**WELWYN HATFIELD COUNCIL – DEVELOPMENT CONTROL**  
**DELEGATED REPORT**

<b>APPLICATION No:</b>	<b>N6/2007/1434/FP</b>
------------------------	------------------------

**DESCRIPTION OF PROPOSAL:** The application outlines the proposal to erect a single storey extension at the front of the existing restaurant to provide additional restaurant space. The extension would protrude from the existing building by 6 metres and would be 9.4 metres wide, to match the width of the existing single storey protrusion from the main building. The extension would feature a flat roof built to a height of 3.5 metres and would feature a mock balcony that would add an additional metre to the height of the structure.

EXISTING & PROPOSED
EXTERNAL ELEVATIONS

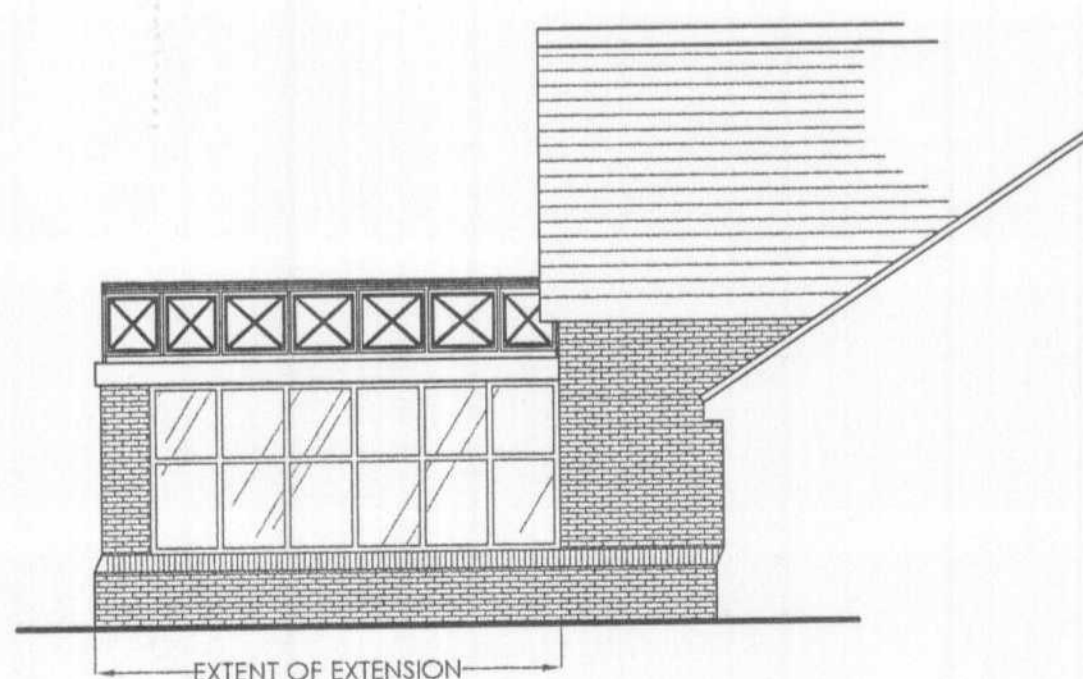
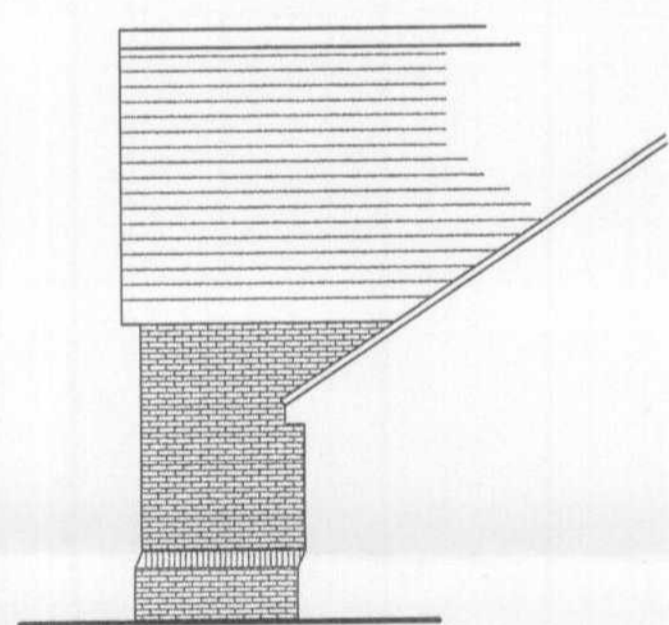
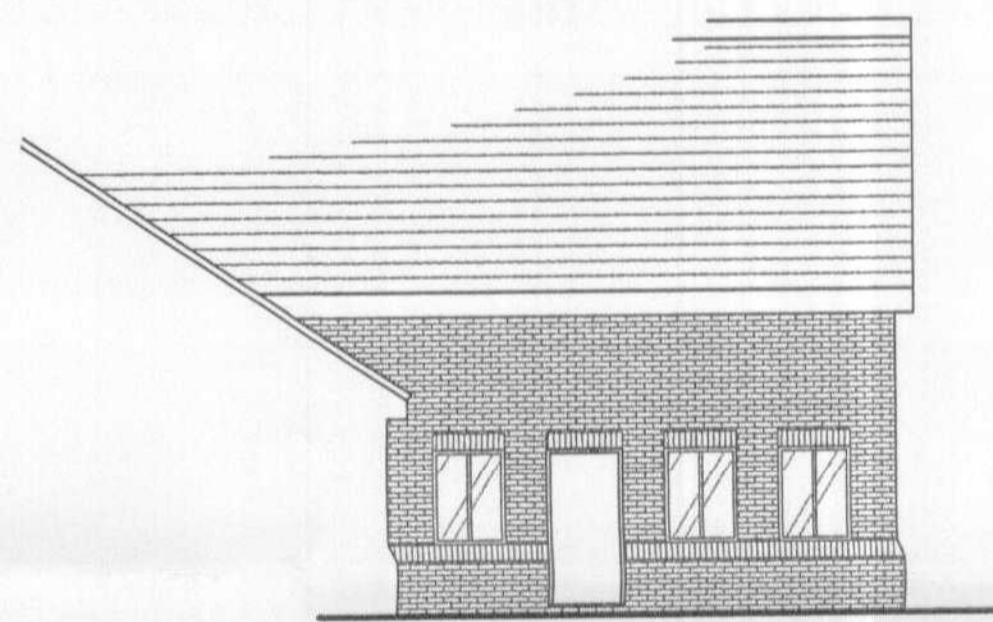
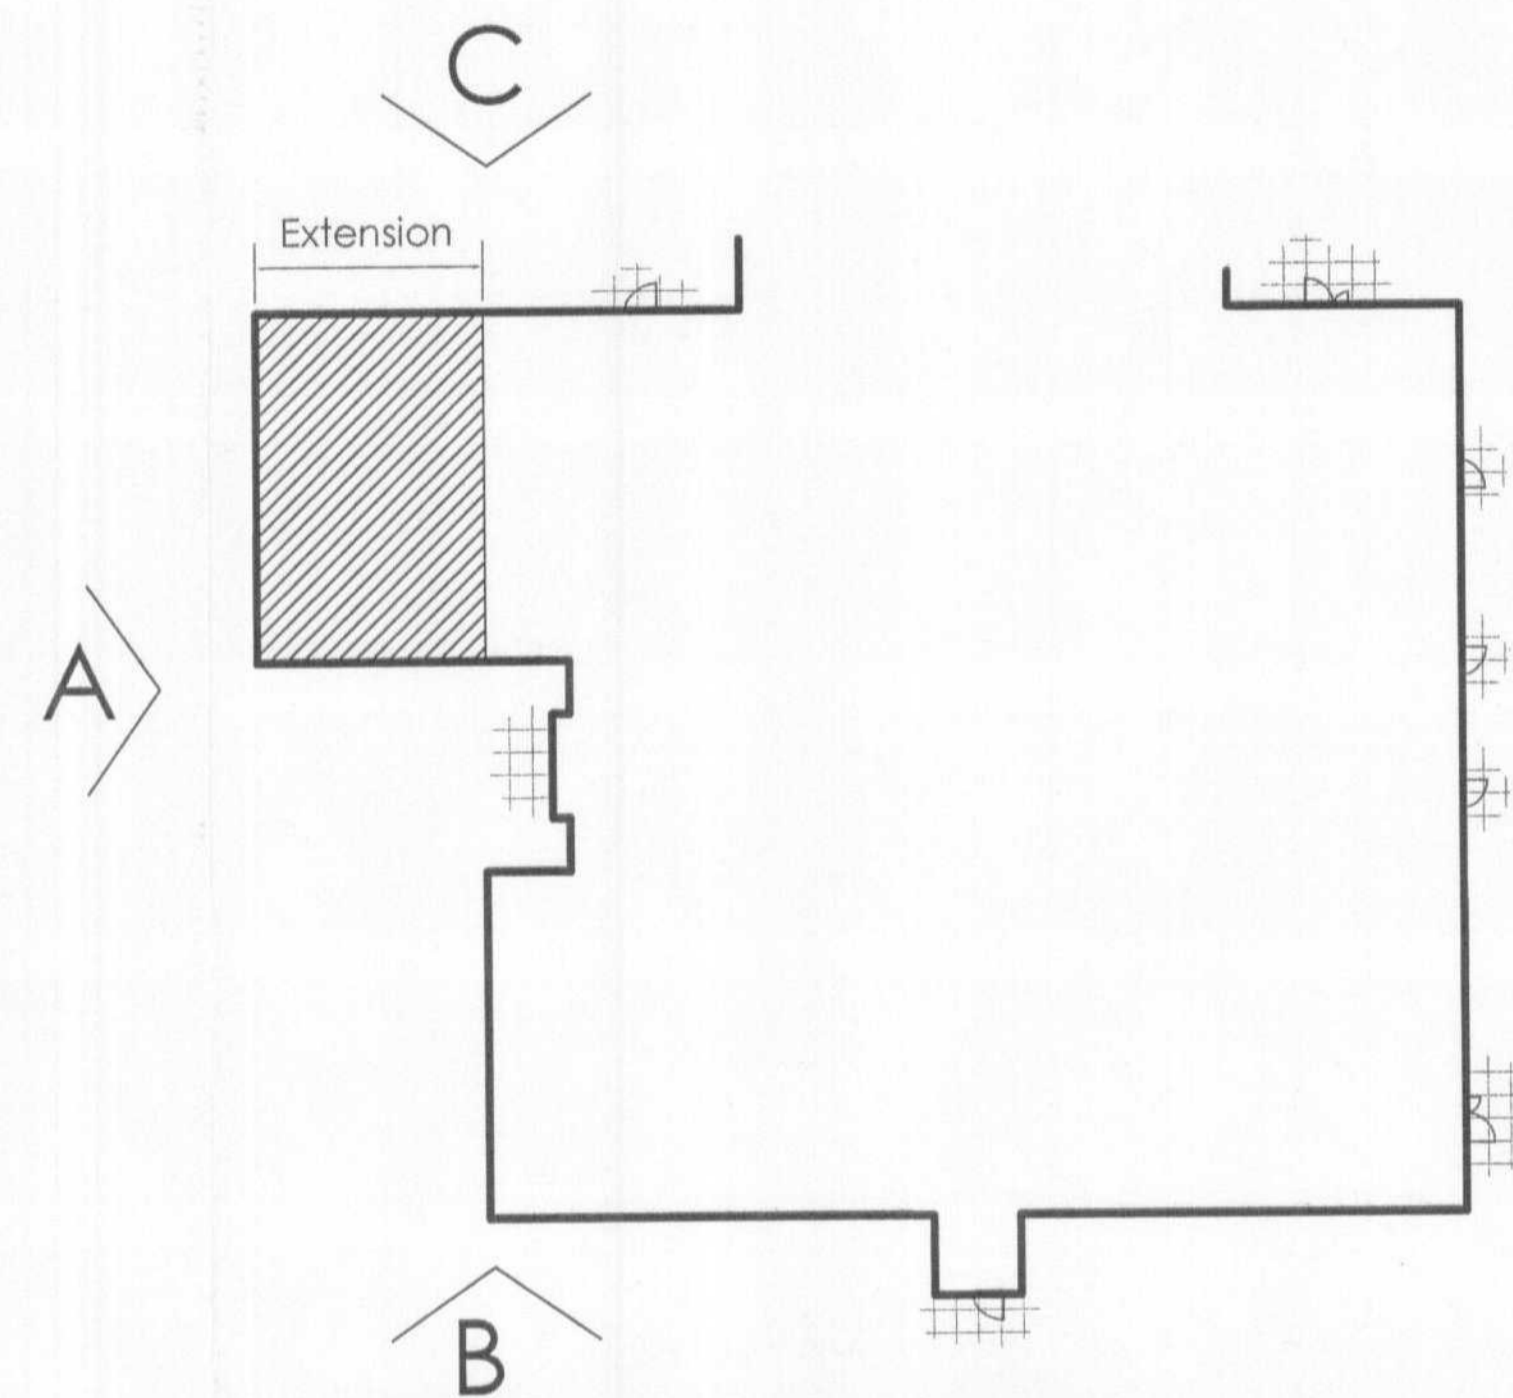
The proposed extension would feature a flat roof which would fail to reflect the architectural style of the existing building and would be out-of-keeping with the visual interests of the site. Whilst it is noted that there is a general preference for single storey extensions in the Garden City to feature a flat roof, in this instance it is considered that the extension should replicate the style of the existing building and feature a pitched roof accordingly. In addition, whilst it is noted that the proposed balustrade would replicate the appearance of the other existing protrusion at the application site, it is considered that the manner in which the proposed balustrade would connect to the eaves of the existing extension would have an awkward appearance that would detract from the architectural merit of the existing building.

The submitted drawings show the retention of the highest level of the existing windows. On consideration of this proposal it is a concern that significant structural works would be required to enable the retention of these windows. Upon discussions with Building Control it has been a concern that this element of the proposal could not be easily weather-proofed and may result in the extension having an untidy appearance to overcome these concerns. Further information was requested in relation to this feature, however this request has been ignored. It is therefore considered that it has not been proven that the extension would not have an untidy appearance and would therefore be likely to have a detrimental impact on the character and appearance of the building and the site.

An important aspect of the design of the existing building is that the entrance at the frontage of the site protrudes beyond the main building line, thereby attracting the eye and providing a degree of legibility to the building. The proposed extension, by virtue of its bulk and positioning would add a significant amount of bulk and mass to the frontage of the property, thereby being unduly prominent to the detriment of the appearance of the site and reducing the legibility and clarity of the building.

Welwyn Garden City  
HERTS  
**The Stanborough**  
**BEEFEATER**  
great grilled food  
PROPOSED PLAN  
(EXTENSION)

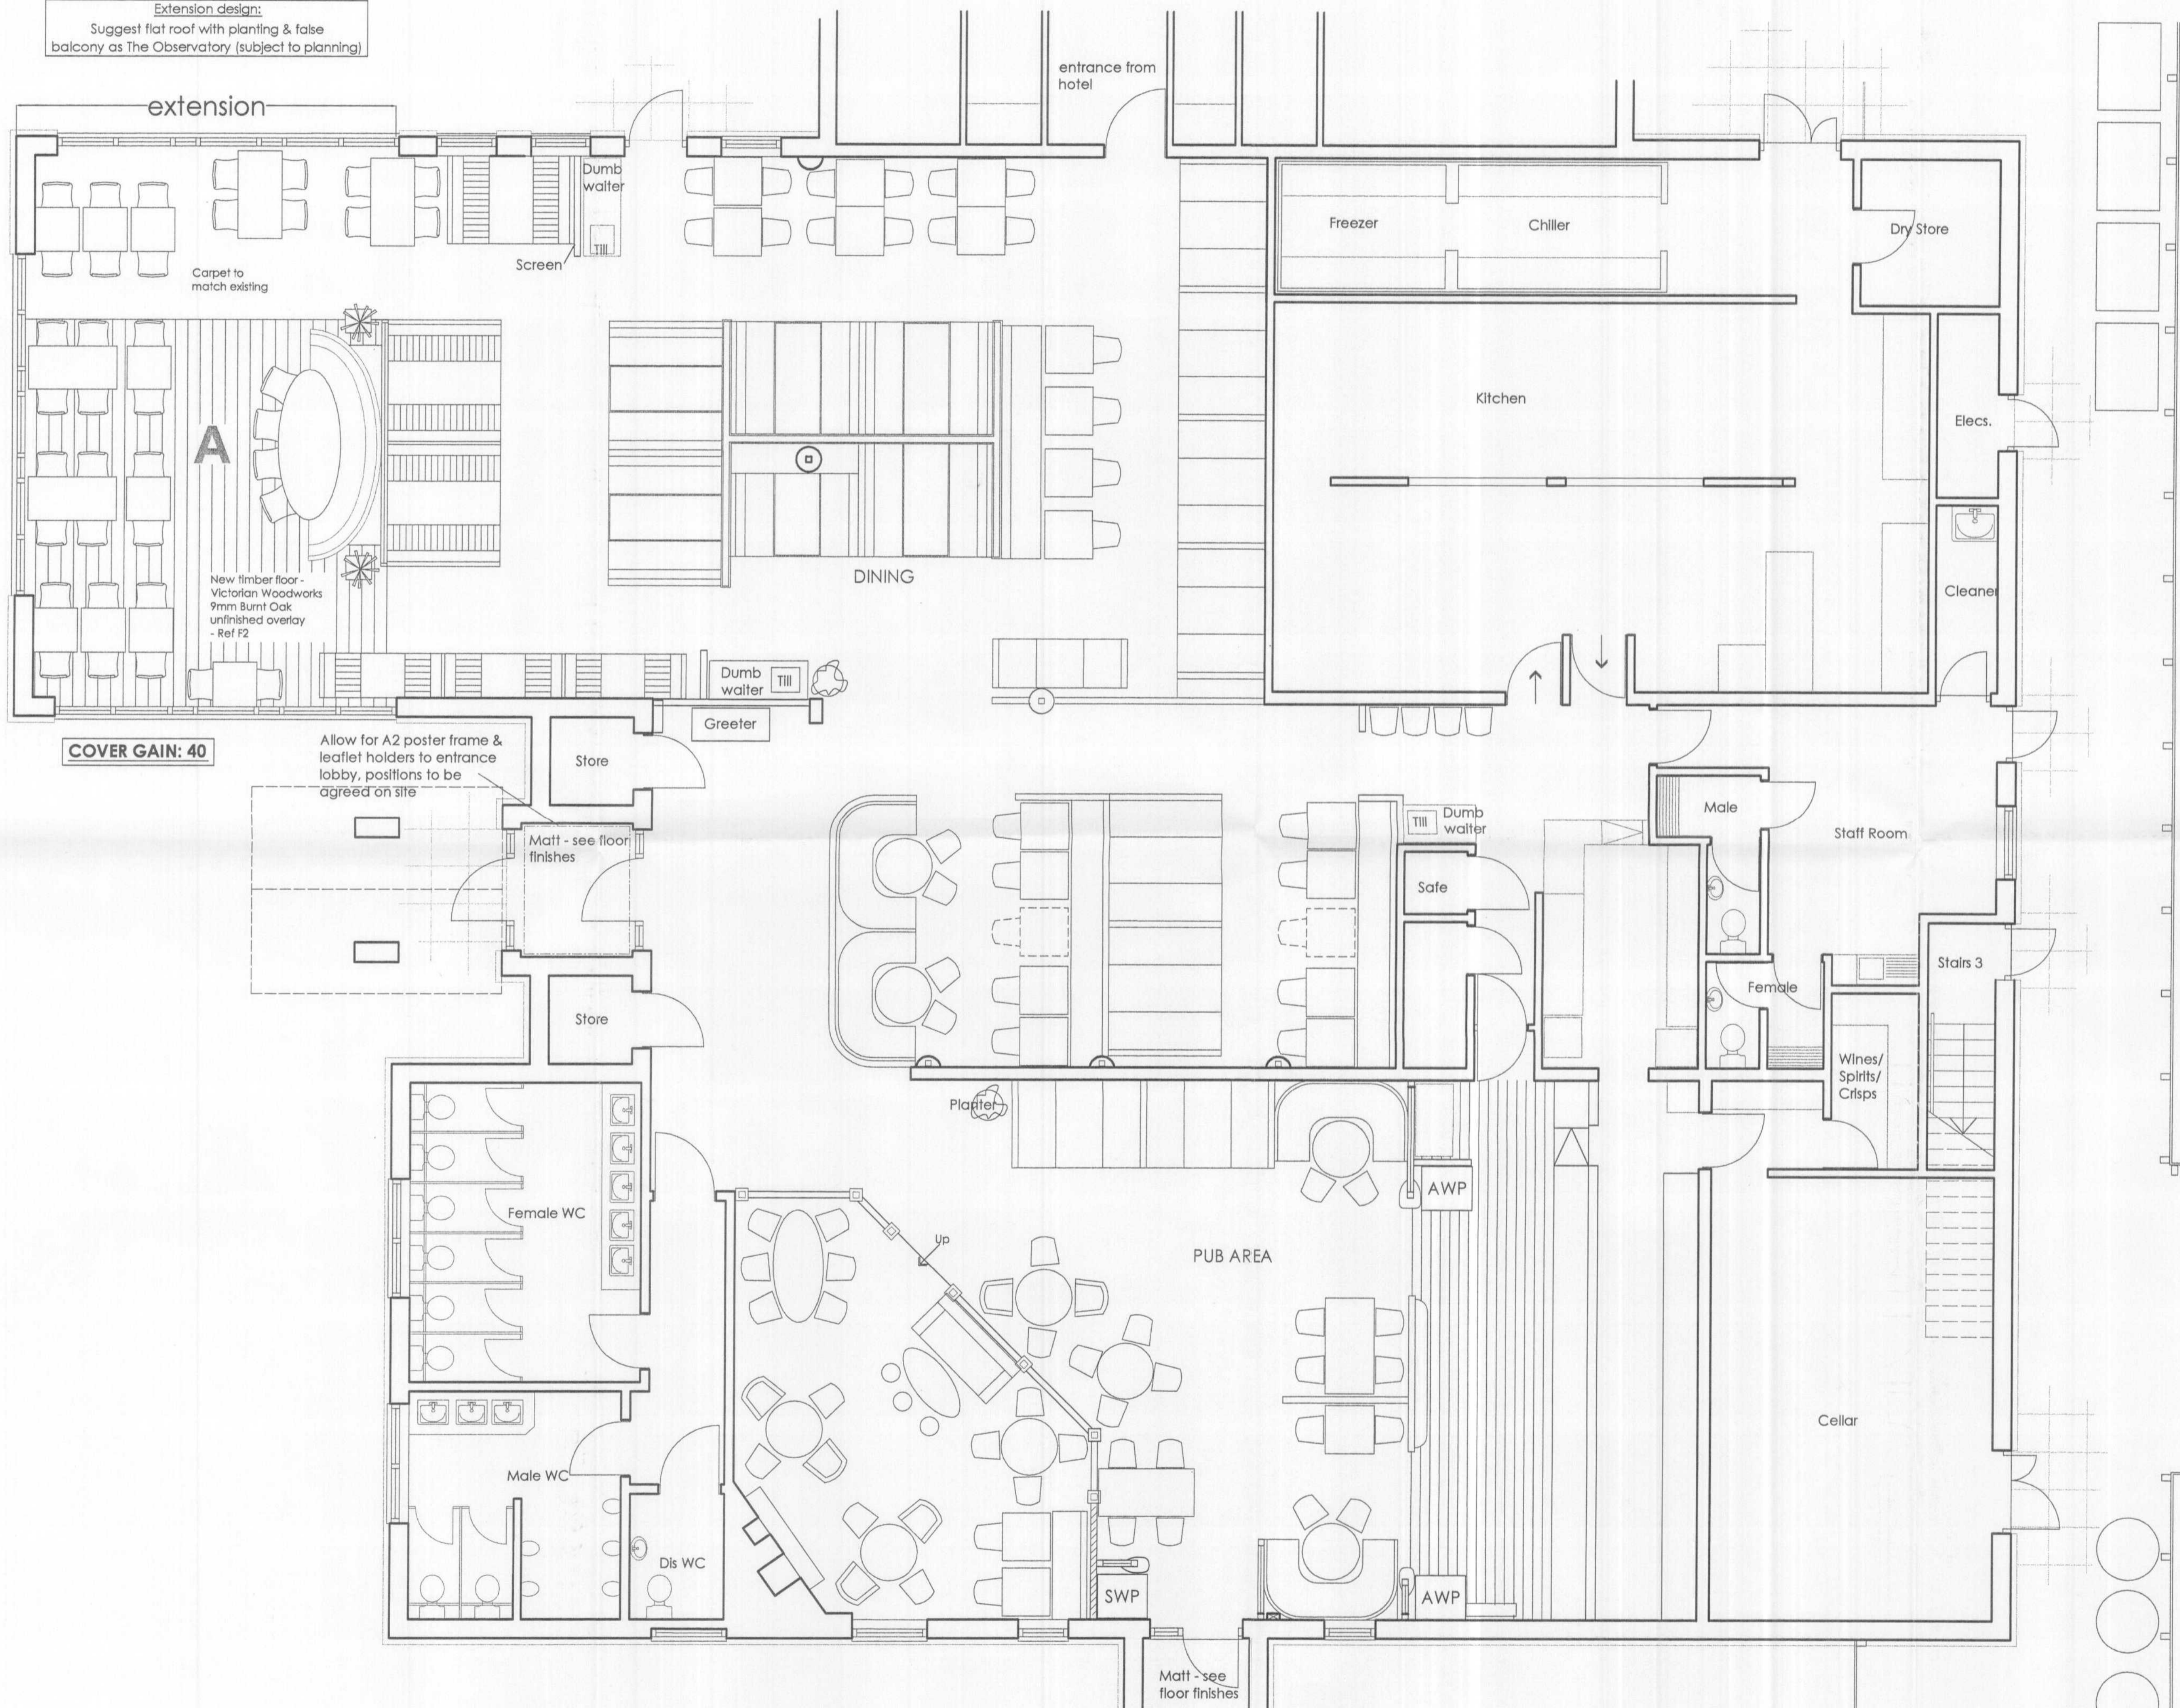
2. The applicant has shown an application site boundary that does not include the land in which the proposed extension would be positioned. On the basis that the failure to include the building within the site boundary would prevent enforcement action being taken if necessary, it is considered that the application should be refused on these grounds. In this instance it is considered that the submission of incorrect plans may prejudice the future ability of the Council to control the

The proposed development, by virtue of the manner in which it would extend onto a prominent walkway, would result in the loss of a designated pedestrian route between the hotel and the restaurant. Although this may result in an increased demand for people to walk within the internal service road, it is considered that the low speed of traffic in this area and the fact that that the service road is privately maintained would mean that it is unreasonable to refuse a planning application on the grounds of highway safety. In addition, as there is a direct internal link between the hotel and the restaurant, it is considered that it would be unreasonable to refuse the application on those grounds.
